Re: The Shire at Old Ranch
Traffic Study Deviation Letter
[Name, Title] El Paso County, Colorado Date

This traffic study letter has been prepared for The Shire at Old Ranch proposed nursery to be located on the northeast corner of the Old Ranch Road and Howells Road intersection in El Paso County, Colorado. A vicinity map illustrating the location of the proposed development is attached as **Figure 1**.

Specifically, this letter has been prepared to provide a deviation request to allow access to the project along Old Ranch Road and Howells Road as directed by El Paso County staff per the El Paso County Engineering Criteria Manual (El Paso ECM), 2016. A deviation is believed to be needed due to County standards identifying that access can only be granted from a lesser category street. Ridgeway Lane to the north is a local roadway whereas Howells Road to the west and Old Ranch Road to the south are collector roadways. It is understood that a deviation is a critical aspect of the review process and needs to be documented to ensure that the deviations granted are applied to a specific development application in conformance with the criteria for approval. It is our hope that this stud

THE SHIRE AT OLD RANCH
 EL PASO COUNTY, CO
 RECOMMENDED
 LANE CONFIGURATIONS AND CONTROL
 SCENARIO 1

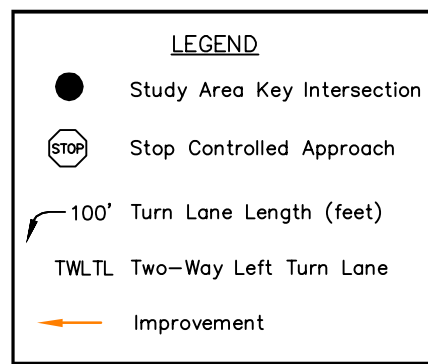
For Scenario 1, redirect taper criteria and recommendation would be required along Old Ranch Road due to the required left turn lane. However, based on discussion with the engineering review manager, the County Engineer will not approve access from Old Ranch Road. Therefore either revise scenario 1 or provide an analysis for a third scenario such as two access on Howells Road or a single access in Howells and Ridgeway. Bottom line is to provide an analysis with no access from Old Ranch Road.
